# Memorandum

Date: June 17, 2025

Re: Response to Comments to Parking Analysis for Self-storage at 9616 Universe Boulevard NW

This memo provides a response to comments from Alan Varela via Shahab Biazar for the Parking Reduction Study for the Self-Storage at 9616 Universe Boulevard NW. Staff comments are in italics followed by the applicant's responses.

Proposed Conceptual Site Plan and Parking Calculations

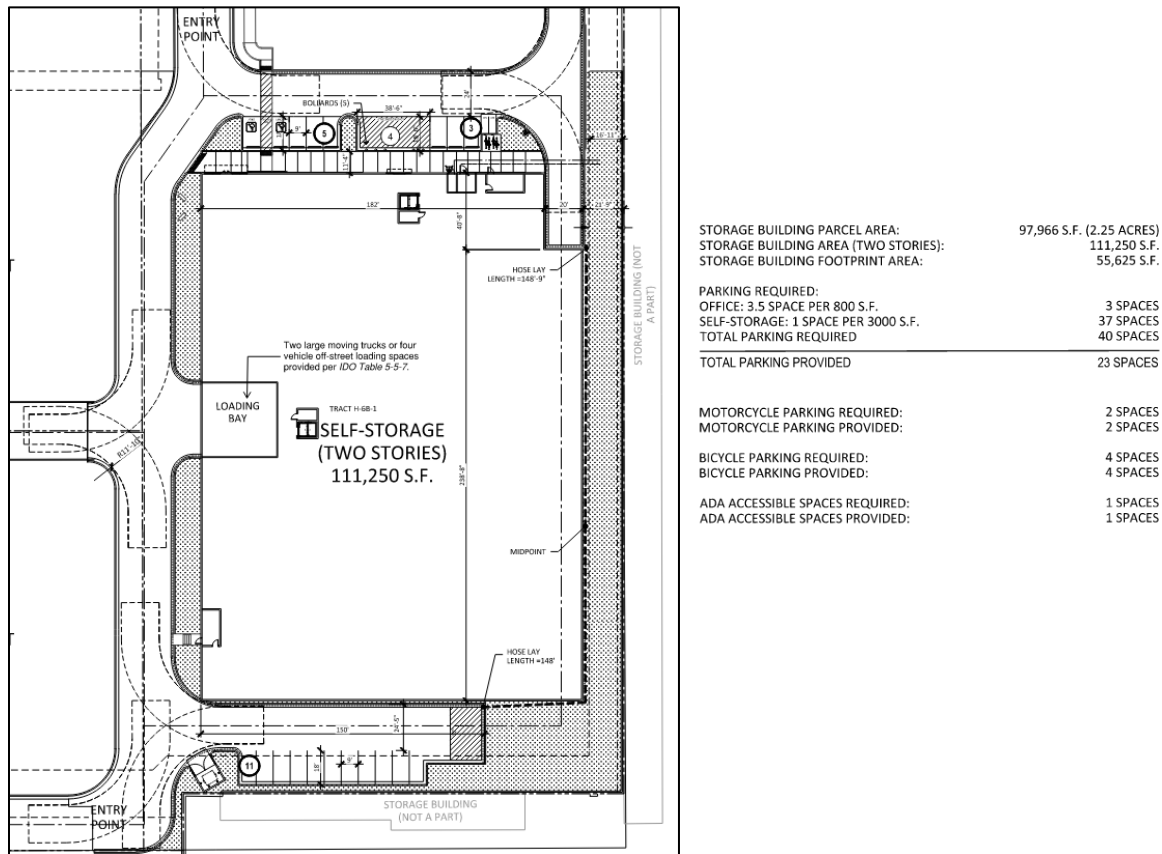
- 4) *On the notes it is mentioned that one handicap parking space is provided. Two handicap parking space as shown on the site plan should be provided based on the original required 40 parking spaces, and one must be a van handicap parking space.*

- 5) *On the north side of the building, four of the spaces are not shown as actual parking spaces. Bollards are shown within the proposed parking spaces.*

**Applicant Response:** The ADA Parking note on the site plan was corrected to state that two parking spaces are provided. The proposed site plan shows two ADA parking spaces including 1 van space.

**Applicant Response:** The four parking spaces are identified as loading spaces that can also be used for parking spaces if needed. The bollards are shown abutting the sidewalk.
